CITY OF ALBUQUERQUE

RE: **Lot 15 Block 4 SAD 228**
Volcano Cliffs Subdivision
6423 Canavio St NW
Grading and Drainage Plan
Engineers Stamp Date 4/27/17 (D10D003D15)
Pad Certification Date: 6/26/17

Based upon the information provided in your submittal received 11/17/17, this plan cannot be approved for Certificate of Occupancy until the following comments are addressed.

ENGINEER'S SEAL 4/27/17 DAVID SOULE P.E. #14522	6423 CANAVIO PLACE	DRAWN BY WCWJ DATE 4-26-17 21731-LAYOUT-4-26-17
	GRADING AND DRAINAGE PLAN 1606 CENTRAL AVENUE SE SUITE 201 ALBUQUERQUE, NM 87106 (505) 872-0999	SHEET # — JOB # 21731

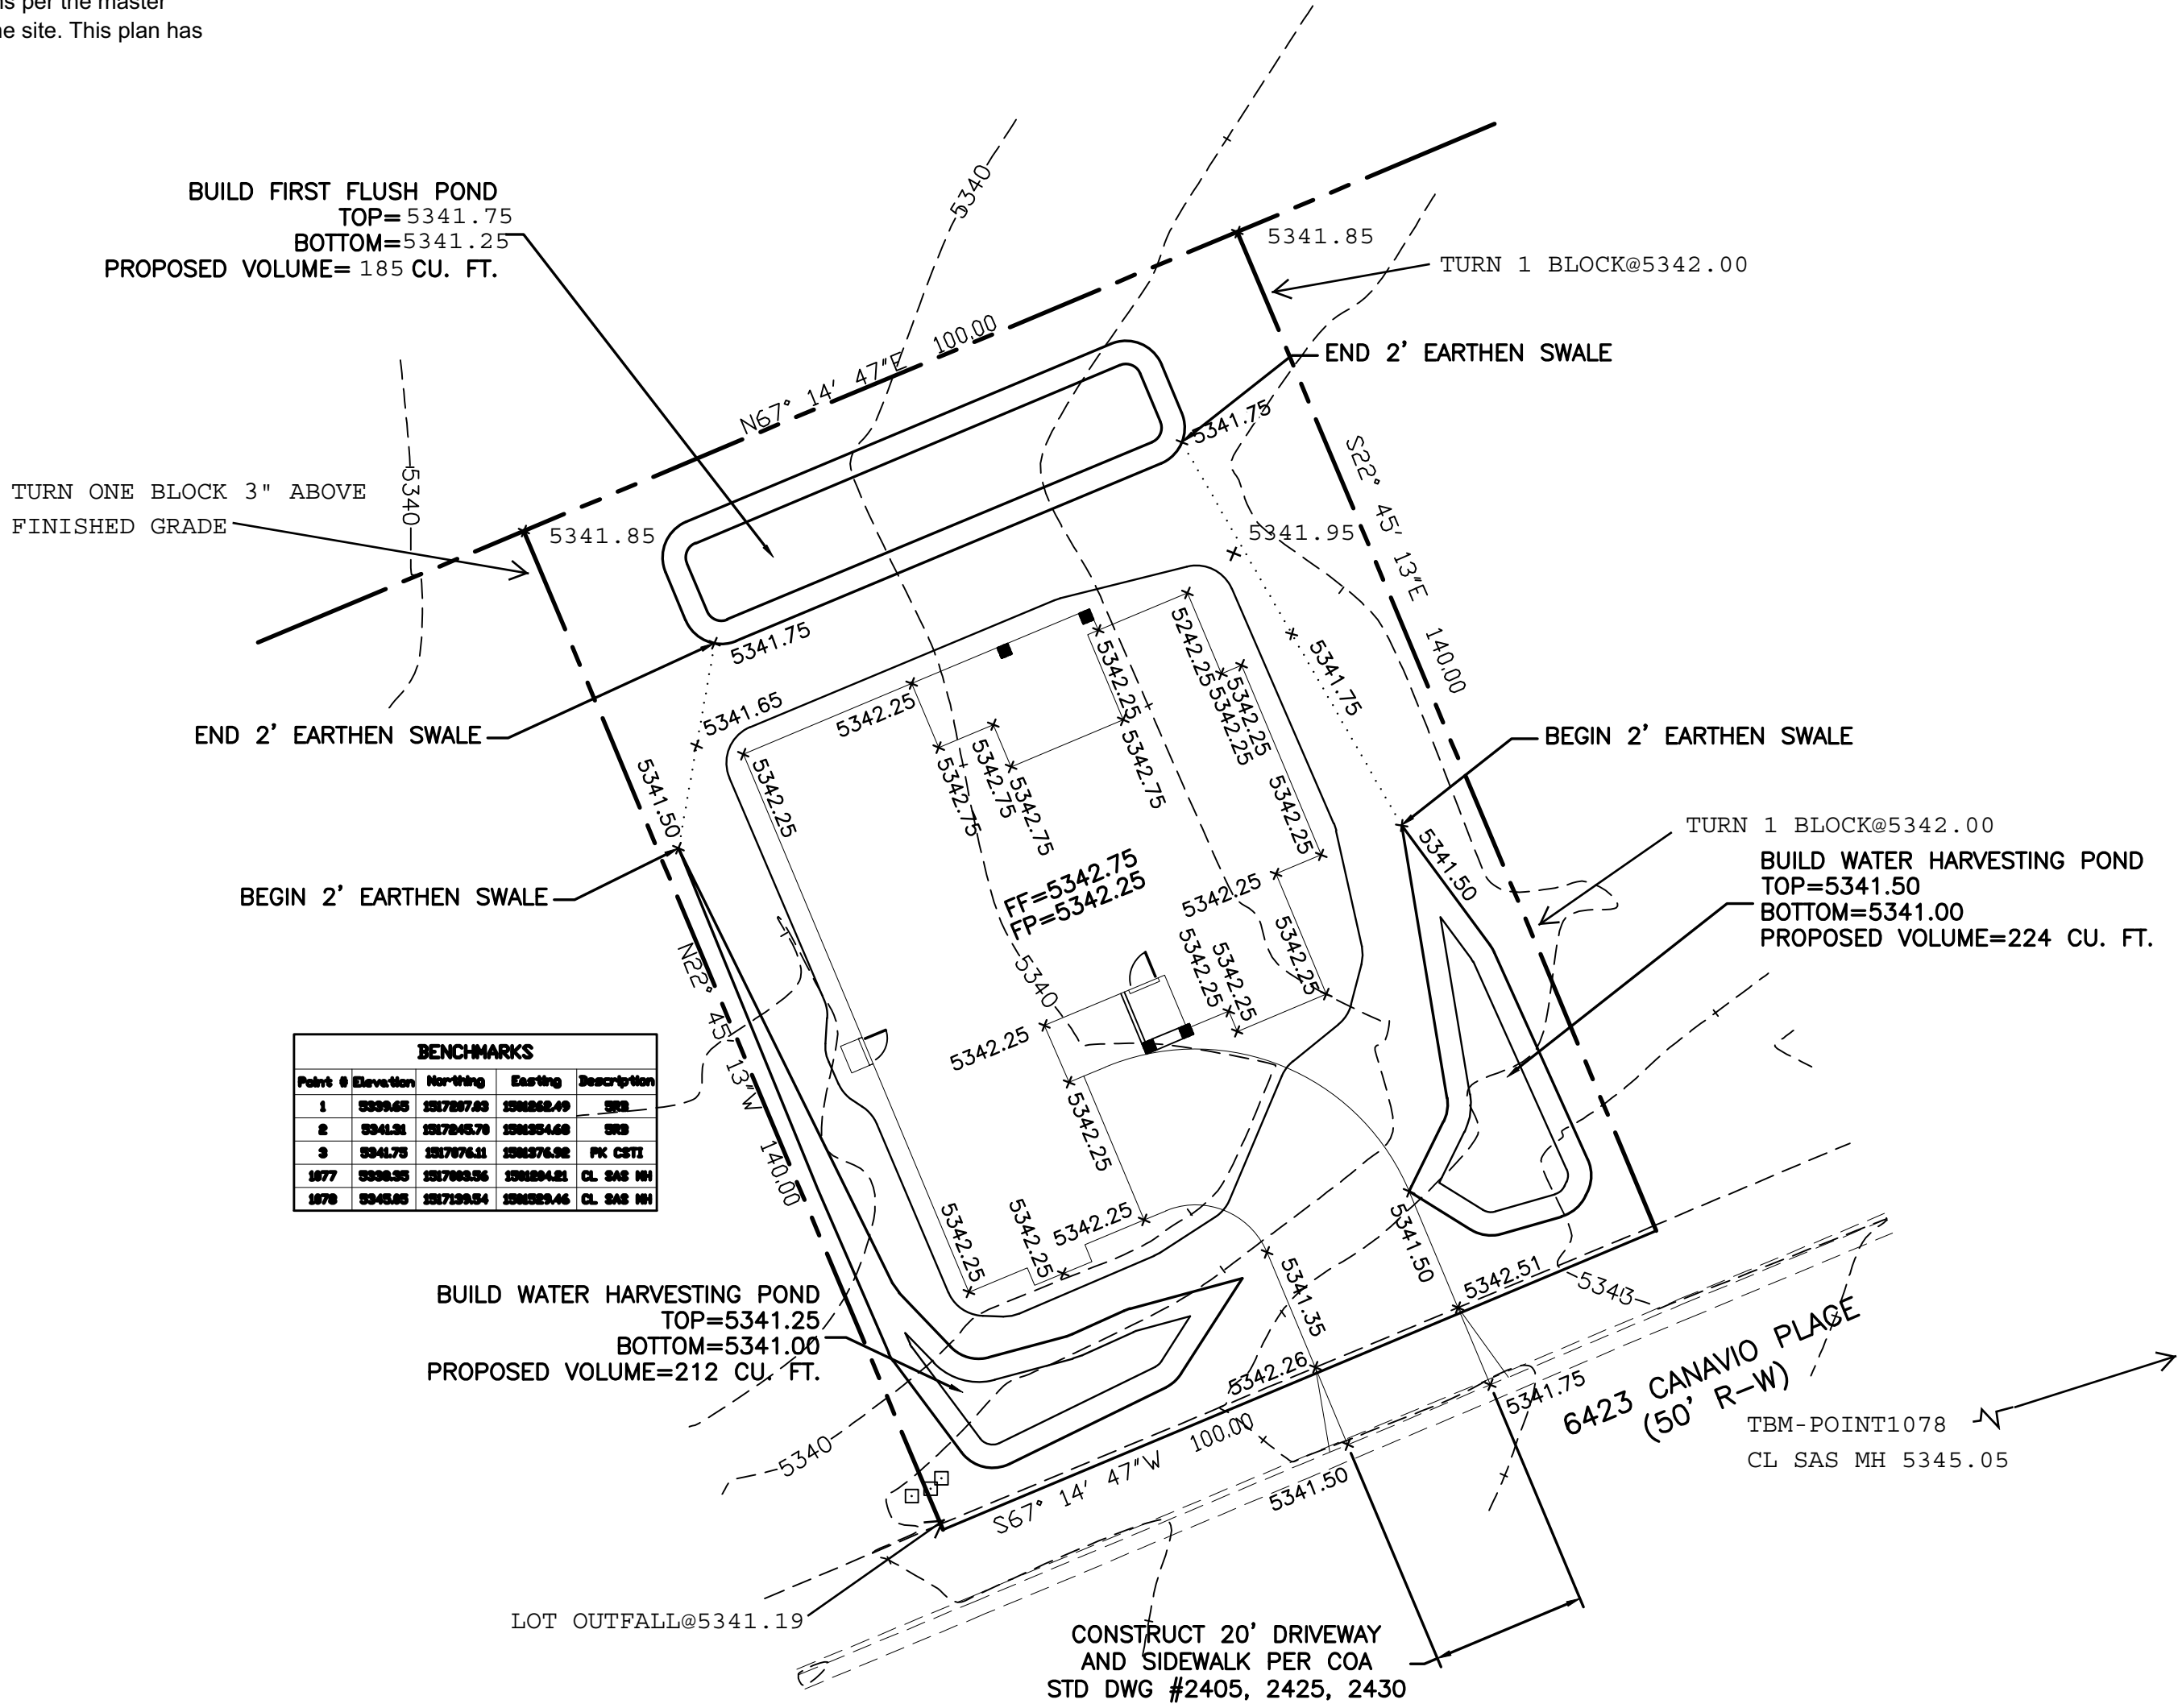
- The swale on the west side of the home is not in place. A retaining wall may need to be installed so a swale can be provided. All flows on this side of the home drain toward the lot to the south.
- A block wall is under construction and the turn blocks were not visible. Is there a permit for this wall? The small block walls coming from the home toward the property lines appear to be obstructing the flows of the swales.
- The pond on the SW corner of the property appears to back flow towards the property to the south, this area needs to be addressed.
